From: alan.story@hertfordshire.gov.uk
To: [Planning](#)
Subject: Planning application 6/2018/1519/MAJ - Land on the north of Chequersfield
Date: 31 October 2018 09:43:43

Response to Planning application from Hertfordshire County Council (T and CP GDP Order 2015)

District ref: 6/2018/1519/MAJ

Erection of 30 residential units with associated vehicular access, associated ancillary and enabling works.

Dwg No: LSD209-01 K
 Rev H: Access updated to suit drawing 22573-08-020-01 Rev C.
 Rev J: Parking updated to suit drawing 10390-250 Rev P3.
 Rev K: Updated to suit new survey information.

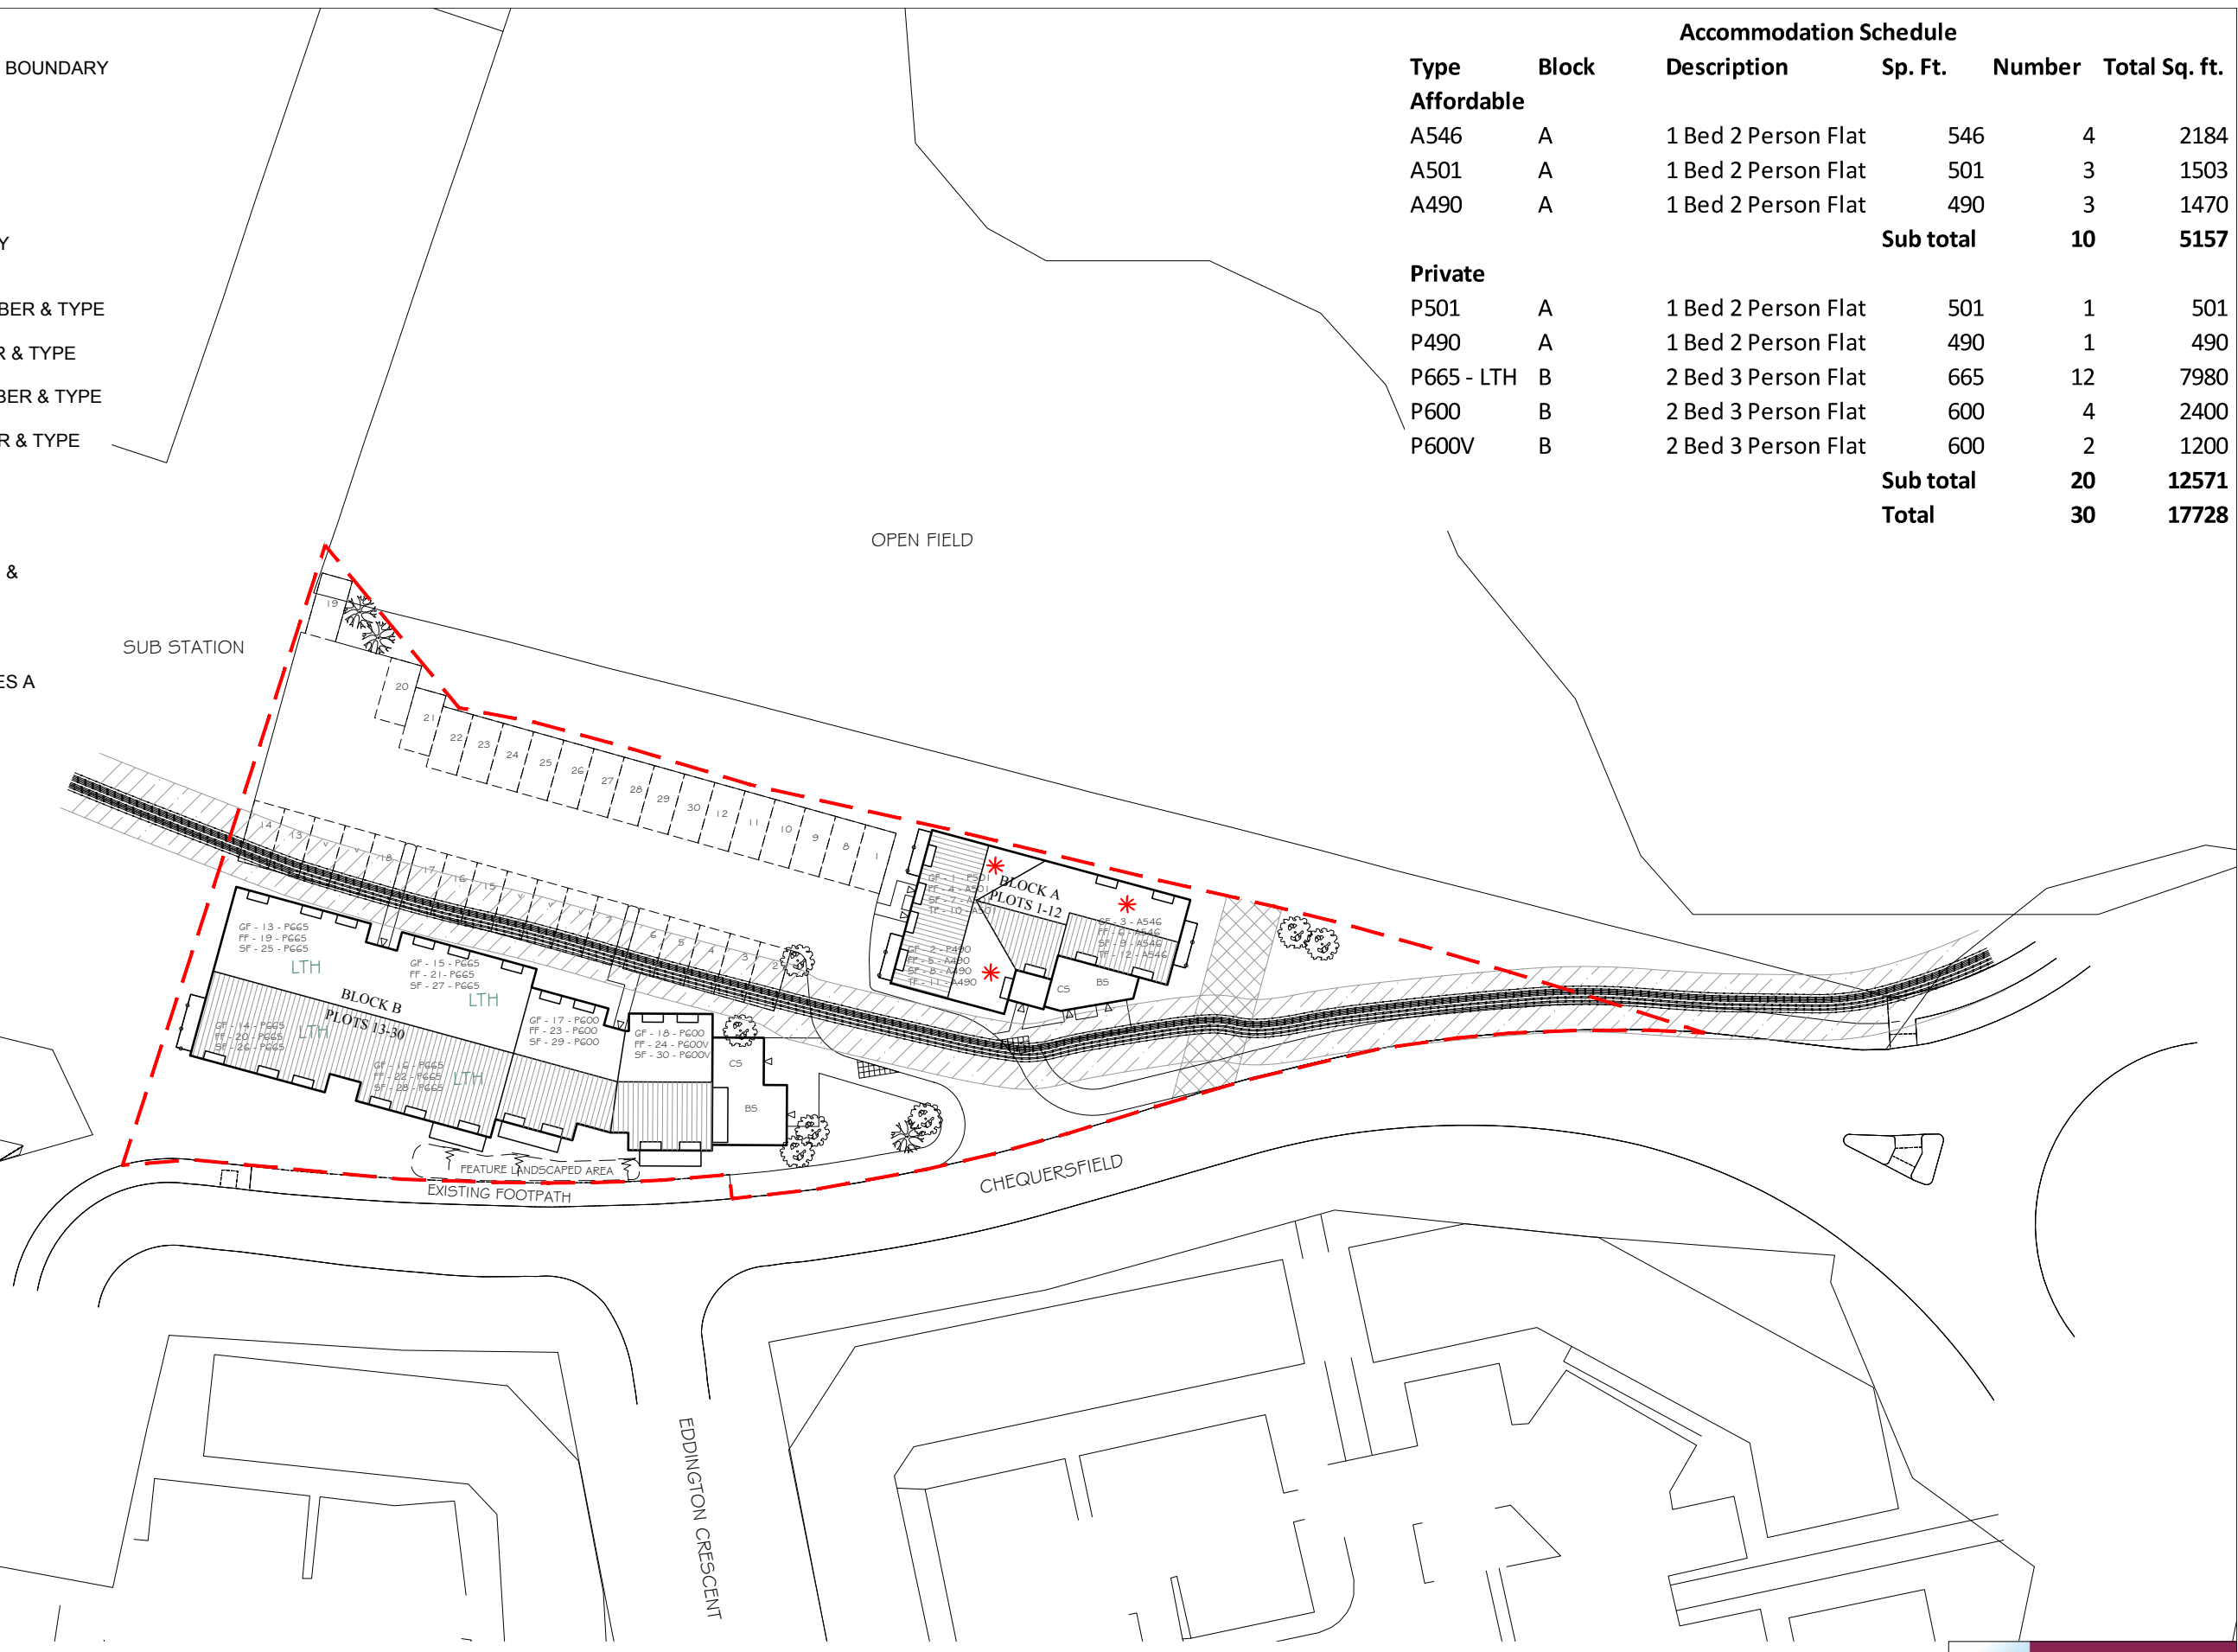
i) Concurrent with the creation of the proposed access, all footway works as shown in principle on drawing LSD209-01 J shall be delivered to the satisfaction of the Highway Authority; Reason : In the interest of promoting sustainable, non-car modes of travel from the development in accordance with the NPPF and LTP4.

1) Prior to the first occupation of the development hereby permitted the vehicular access shall be provided and thereafter retained at the position shown on the approved plan drawing number LSD209-01 Rev J to the Highway Authorities requirements and standards. Arrangement shall be made for surface water drainage to be intercepted and disposed of separately so that it does not discharge from or onto the highway carriageway. Reason: To ensure satisfactory access into the site and avoid carriage of extraneous material or surface water from or onto the highway.

2) Prior to the first occupation of the development hereby permitted a visibility splay shall be provided in full accordance with the details indicated on the approved plan number (LSD209-01 Rev J). The splay shall thereafter be maintained at all times free from any obstruction between 600mm and 2m above the level of the adjacent highway carriageway.

The applicant has submitted revised details by way of revised block plan (LSD209-01 J) and updated Transport Statement (M-EC Consulting Engineers, October 2018).

The residential development, comprising a mix of 1 and 2 bedroom units, proposes 30 car parking spaces (1 per dwelling) as well as a 5 visitor spaces (a discrepancy is noted between submitted plans and TS – the TS describes 37 parking spaces be provided versus 35 as shown on drawing LSD209-01 rev J).
